Consultation Response from KC, Conservation & Design**2024/92386 1-22, The Arcade, 14 & 16, Corporation Street, 23 & 25, Market Place, Dewsbury, WF13 1QG****Discharge details reserved by conditions 16 (signage), 17 (colour scheme) and 21 (trickle vent details) of previous permission 2023/91134 for variation condition 2 (plans) on previous permission 2021/93190 for alterations to the building and material change of use of units to flexible uses falling within Use Classes E (a), (b), (c), (d), (g(i)), (g(iii)), public house/wine bar/drinking establishment****Date Responded: 16.9.2024****Responding Officer: Sue Brooks****Responding Ref:**

This application relates to internal and external alterations at 1-22 The Arcade, 14 & 16 Corporation Street and 23 & 25 Market Place, Dewsbury, WF13 1QG – 2023/91134.

DRAWING NO.  
1705-BDP-AD-00-DT-A-20005

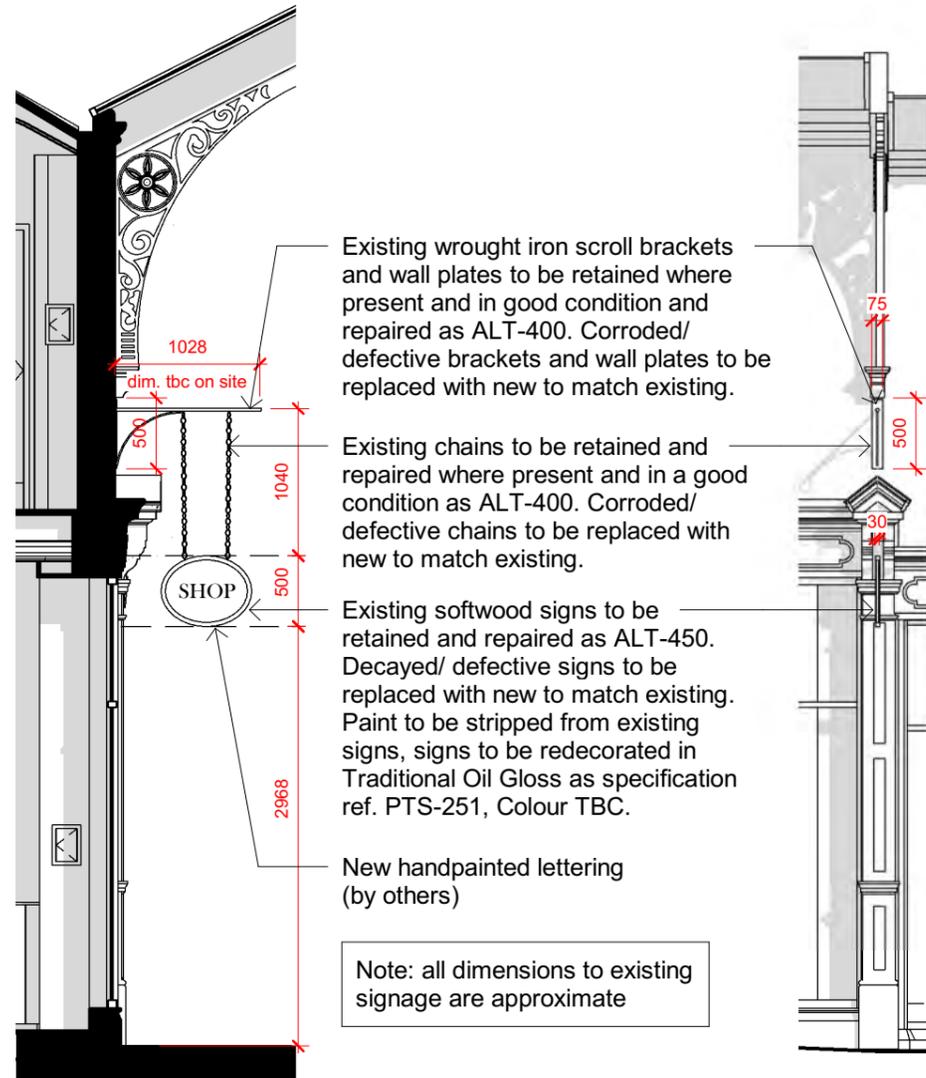
With regards to discharging Condition 16, details have been submitted on Hanging Signage Details (1705-BDP-AD-00-DT-A-20005_C01). The condition was imposed to ensure that the detailing of the hanging signage does not harm the character and significance of the listed building. The information provided is detailed enough to discharge condition 16 as the details show that the existing traditional hanging signage and brackets will be refurbished where possible, with any replacement parts matching the existing to ensure a consistent approach.

PROJECT TITLE Dewsbury Arcade	
BDP JOB NUMBER P3001705	
DRAWING TITLE Roof Truss Colour Scheme	SCALE @ A3 Not to scale
DRAWING NO. 1705-BDP-AD-RF-DT-A-27001	DATE FIRST ISSUED 21.08.2024
REVISION C01

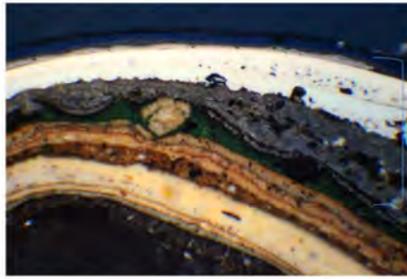
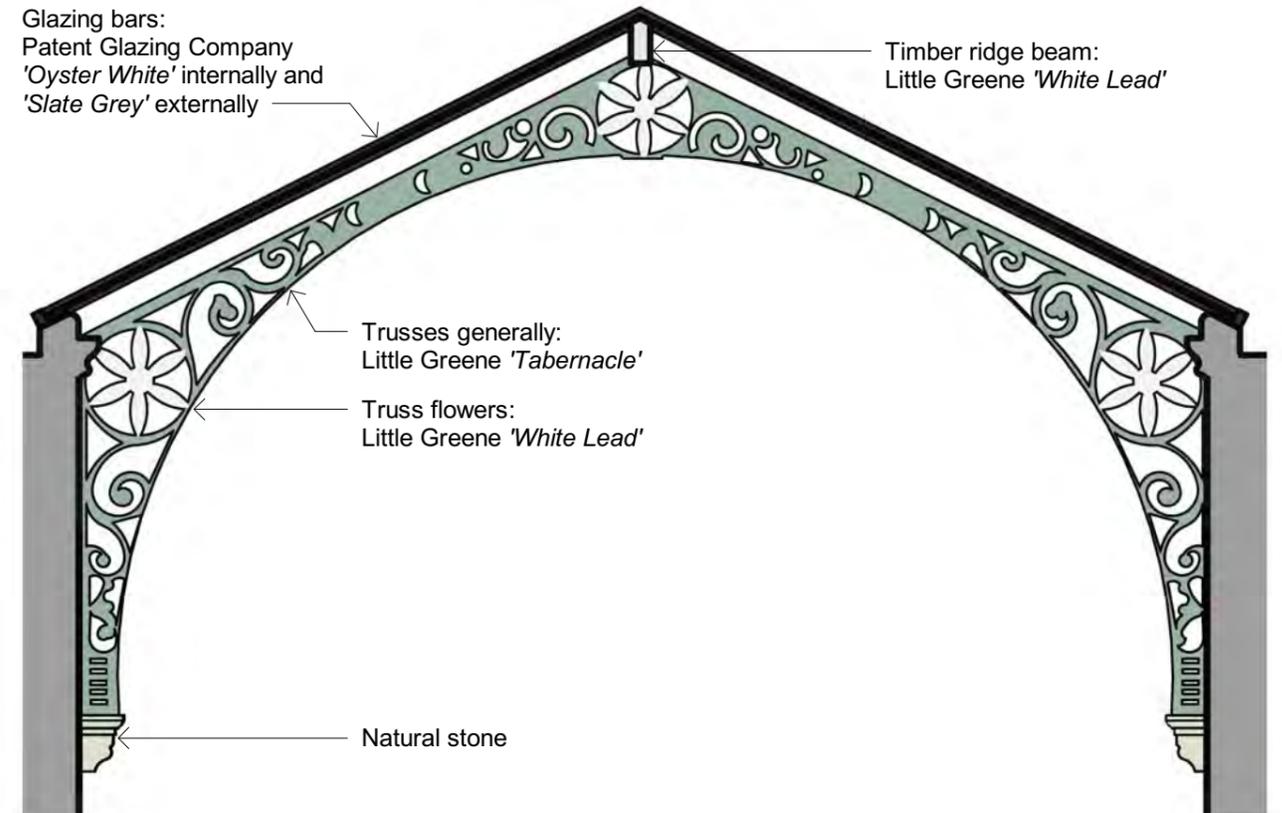
With regards to discharging Condition 17, details have been submitted on Roof Truss Colour Scheme Details (1705-BDP-AD-RF-DT-A-27001_C01). The document includes extracts from a paint analysis showing the historic colour scheme, along with a truss detail showing the proposed colour scheme. The condition was imposed to ensure that the colour of the trusses does not harm the character and significance of the listed building. The information provided is detailed enough to discharge condition 17 as it provides evidence of the historic colours which justifies the proposed colour scheme.

DRAWING No.
1705-BDP-AD-XX-DT-A-31104

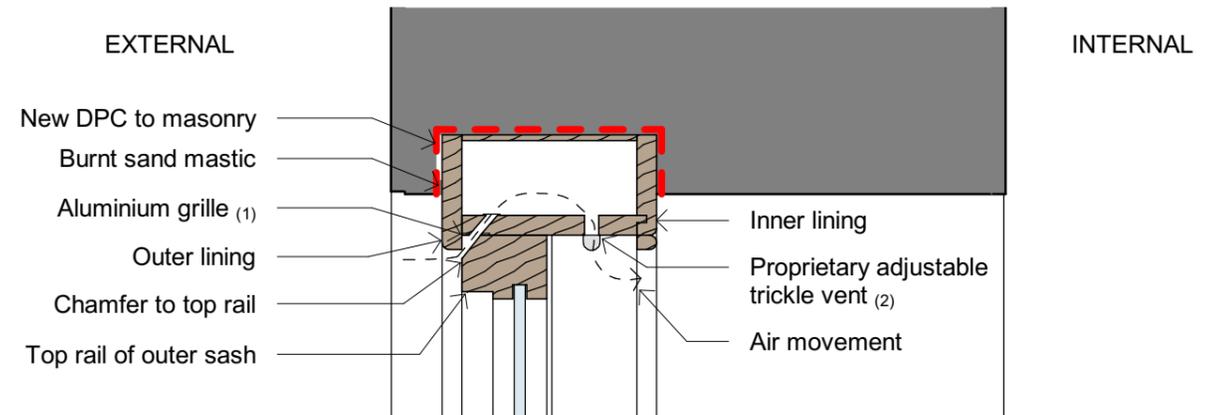
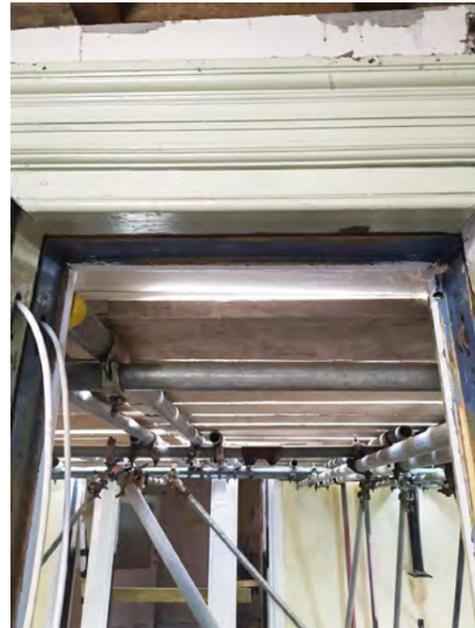
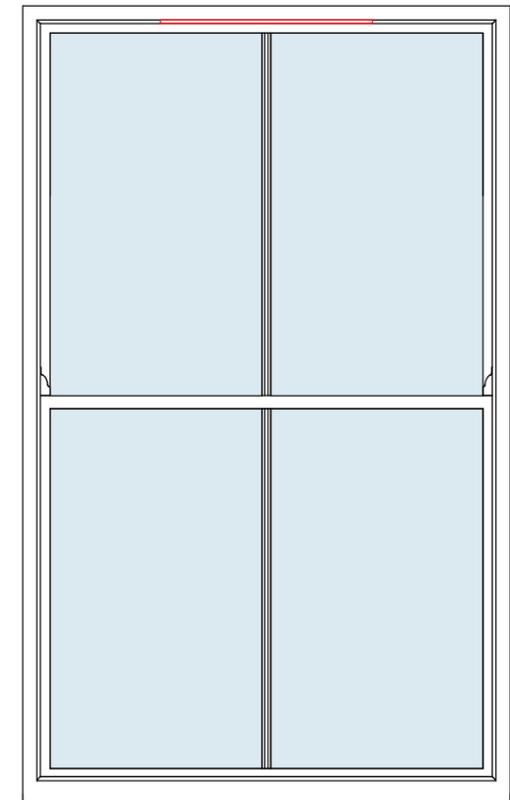
With regards to discharging Condition 21, details have been submitted on Window Trickle Vents Details (1705-BDP-AD-XX-DT-A-31104_C01). This submission includes images of a sample sash window which has been altered to incorporate the proposed trickle vents. A construction detail drawing shows that slots will be cut out of the frame head, with an adjustable trickle vent fitted to the internal frame head and an aluminium grille fitted above the top sash. A small section of the top sash frame is chamfered, allowing airflow to enter the room via the grille and trickle vent. The condition was imposed to ensure that the trickle vents do not harm the character and significance of the listed building.

The information provided is detailed enough to discharge condition 21 as it demonstrates that background ventilation can be provided with very little impact on the significance of the sash windows.
